# PONDEROSA AT LORSON RANCH FILING 3

## A PLANNED UNIT DEVELOPMENT AND PRELIMINARY PLAN

REV #	REVISIONS	DATE
1	1st Response to County Comments	1.8.2020
2		
3		
4		
5		
6

PUD SITE PLAN  
**P5** of 10

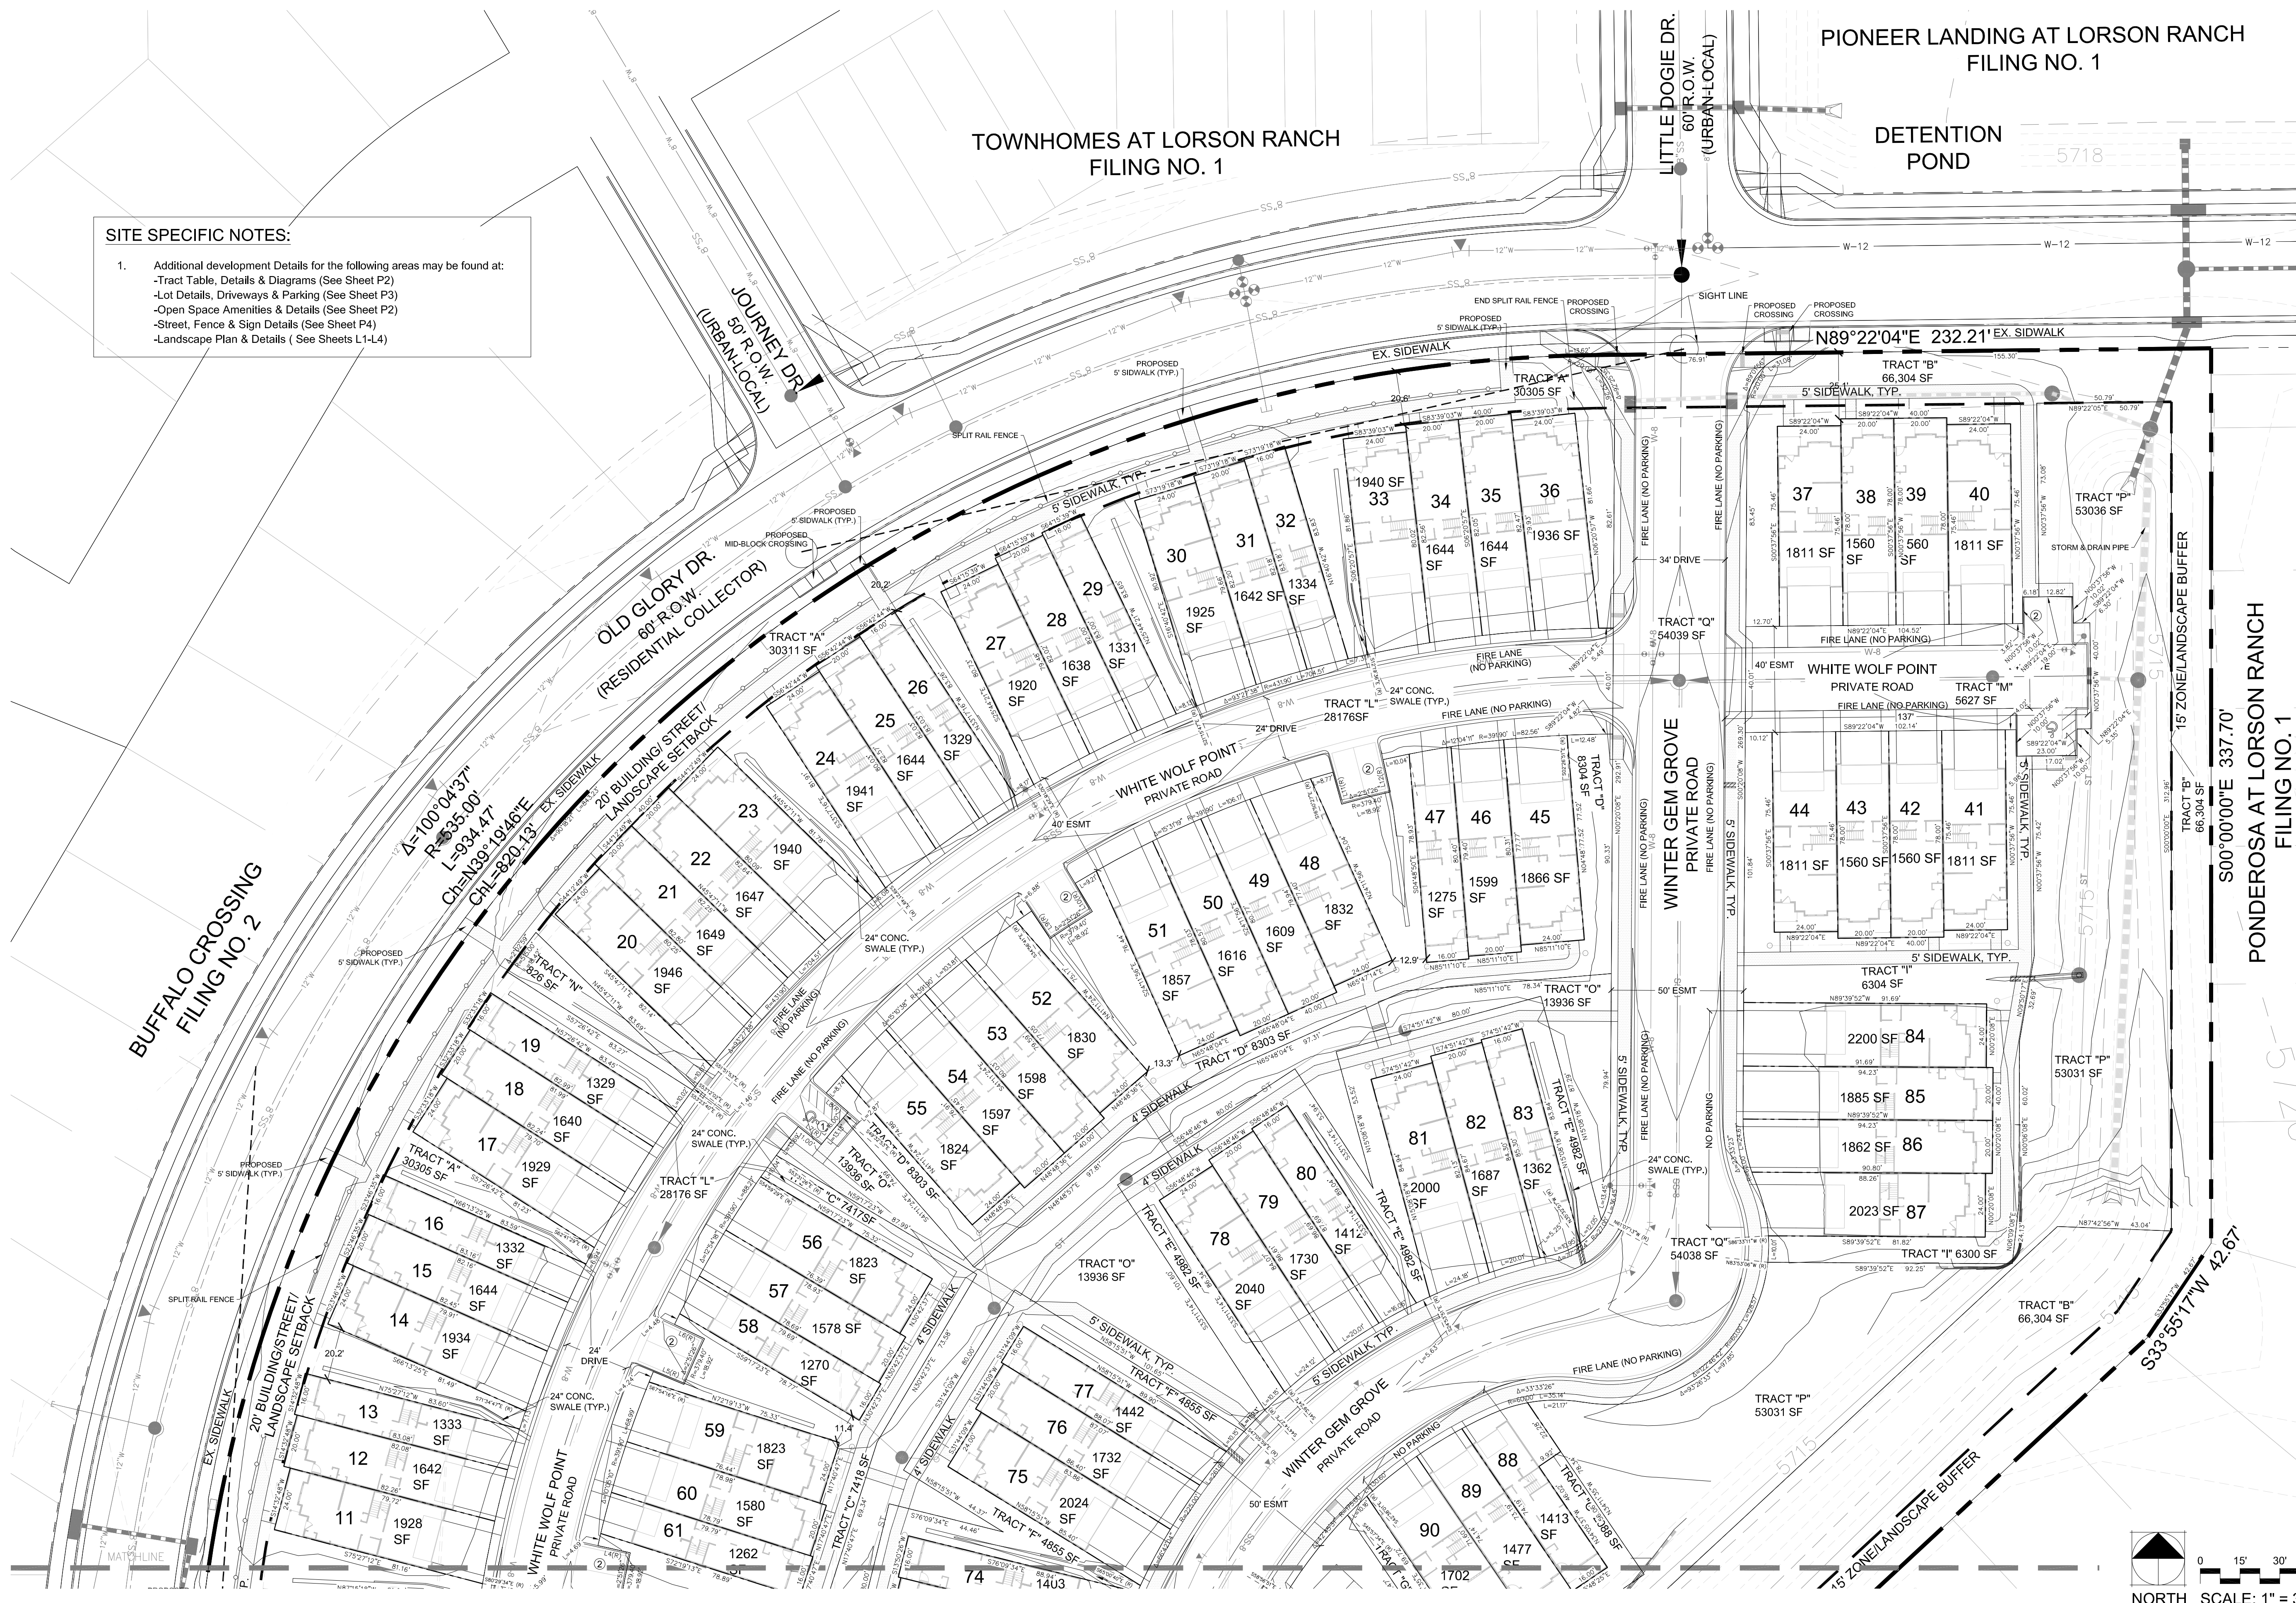
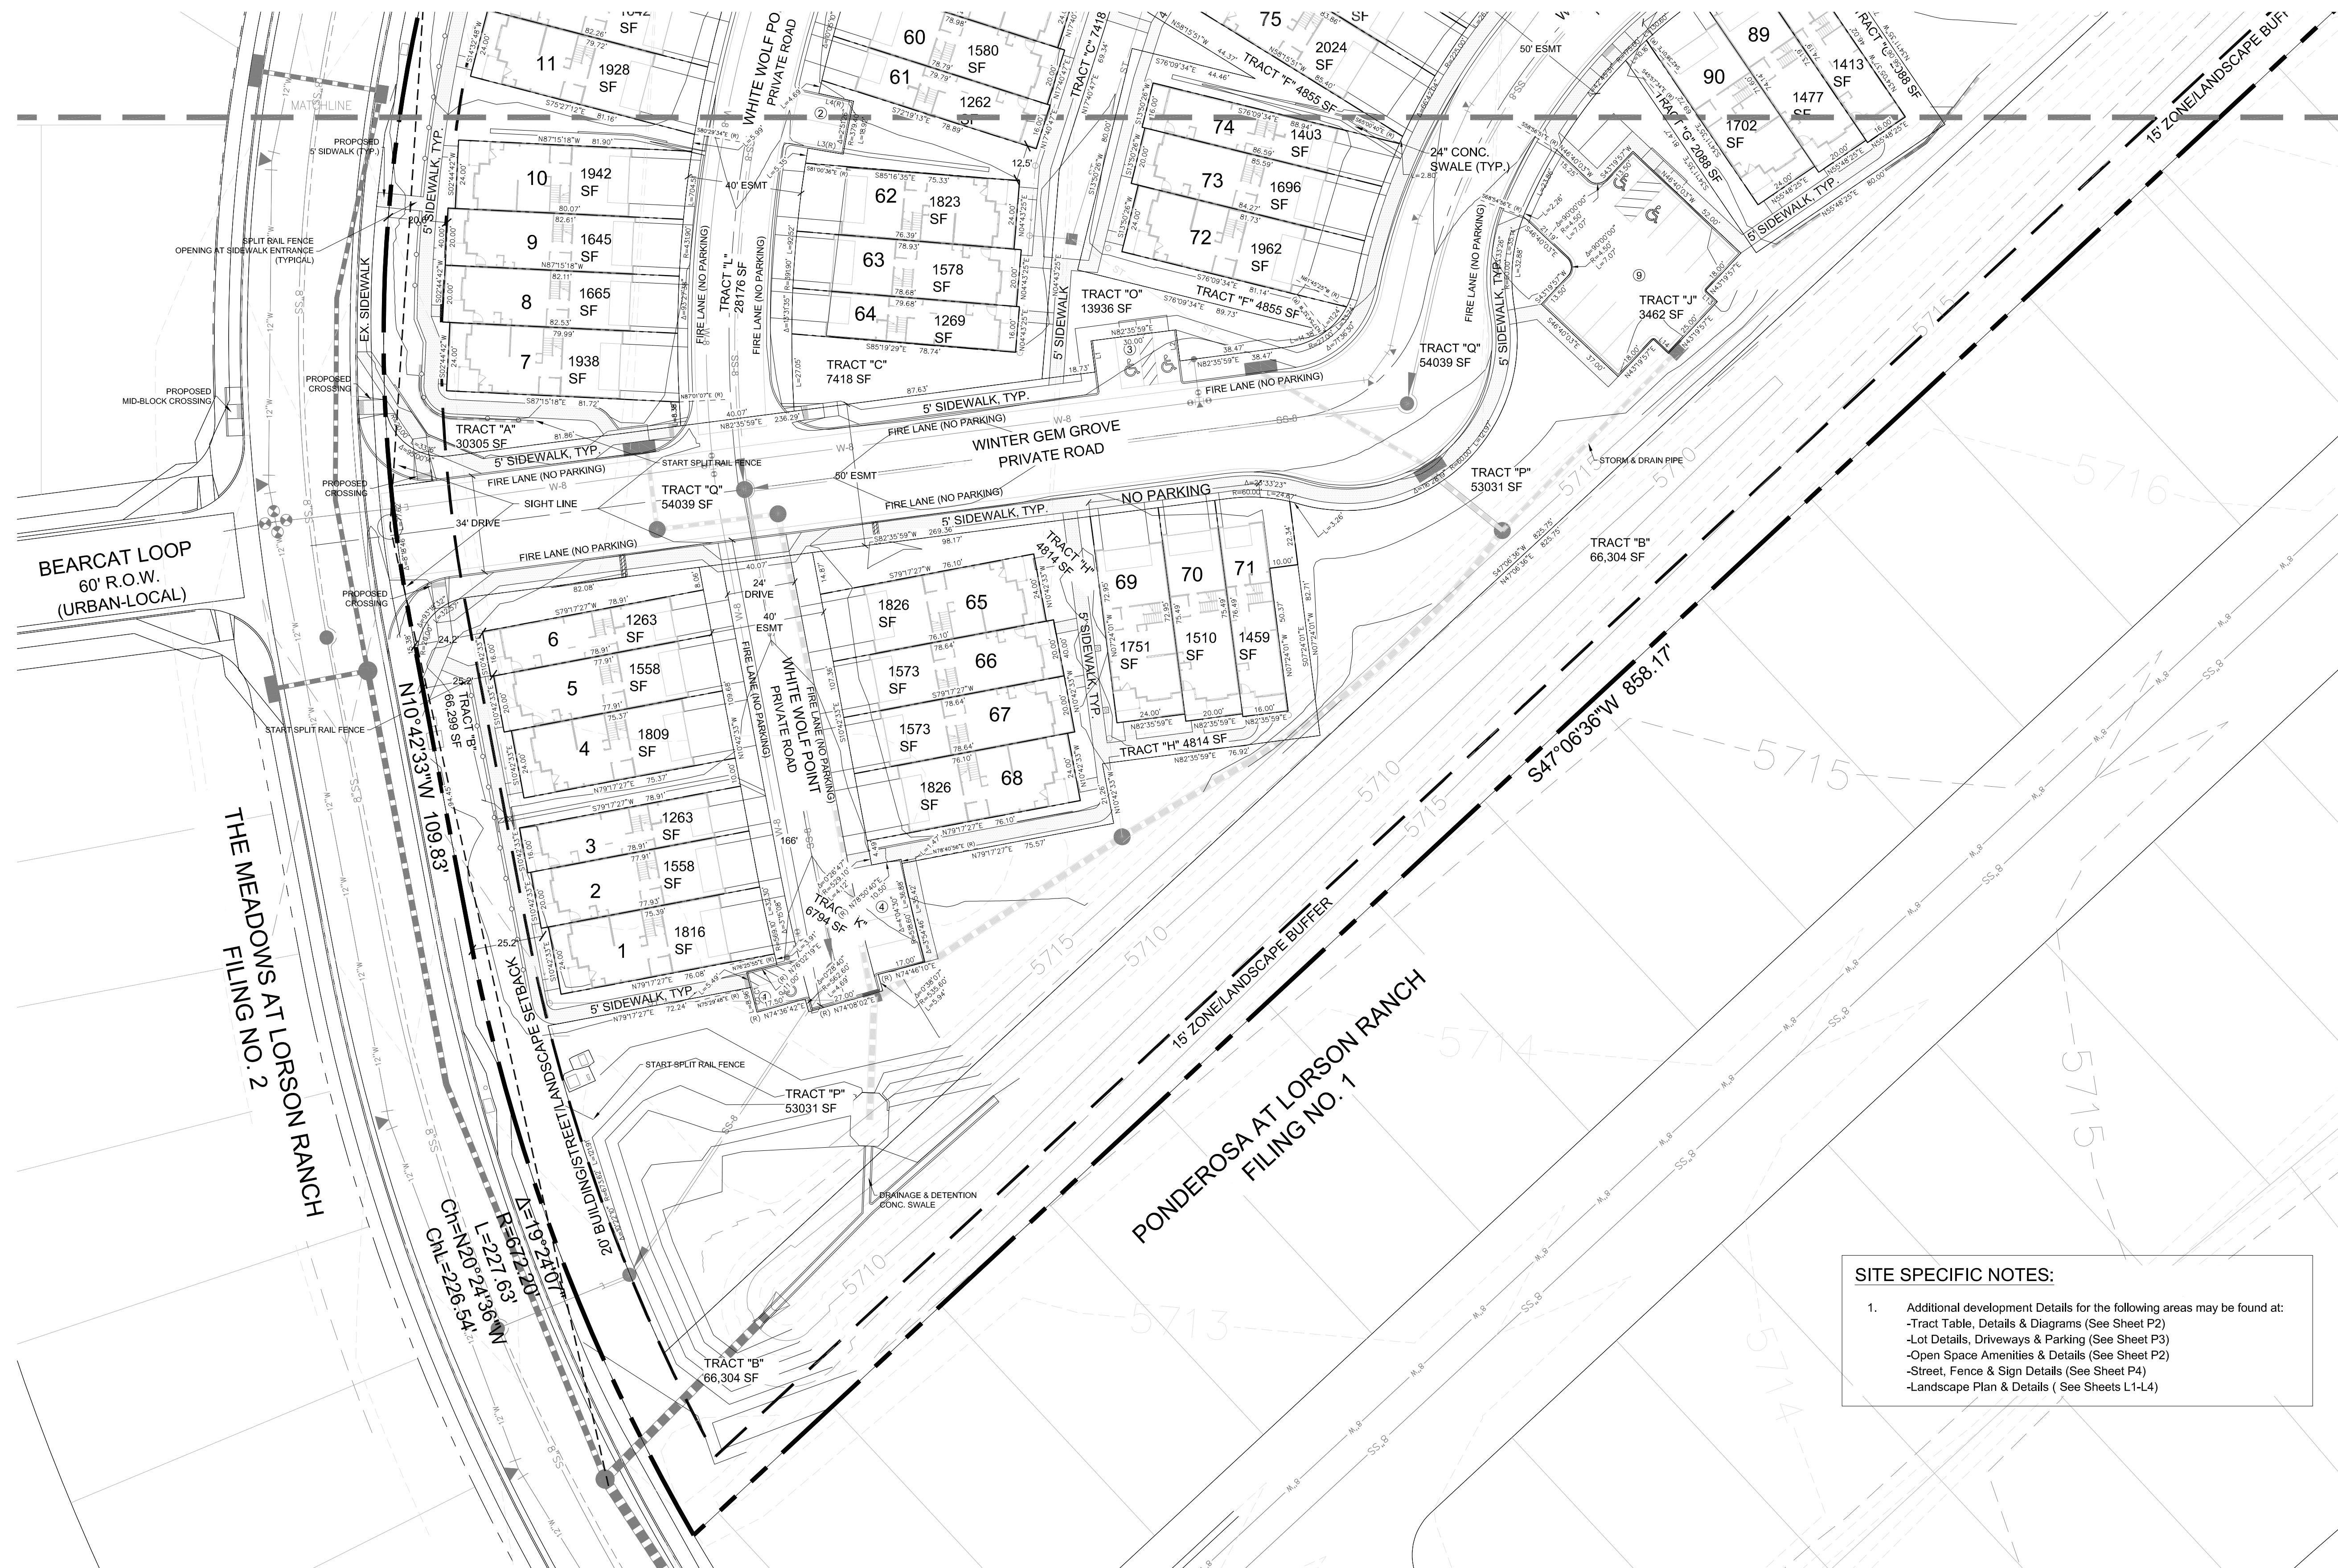
LABEL SIDEWALKS SO ITS CLEAR CONNECTIVITY TO OLD GLORY AND EX SIDEWALKS? NEED RAMP AT INTERSECTION?

label all drainage facilities

IT IS NOT RECOMMENDED TO HAVE A COMMUNITY PARKING SPOT IMMEDIATELY ADJACENT TO A HOMES WALL & WITHIN LOT 88 (FOR OTHER LOTS) FOR OBVIOUS SAFETY REASONS -REMOVE PUBLIC SPACE FROM LOT 88.
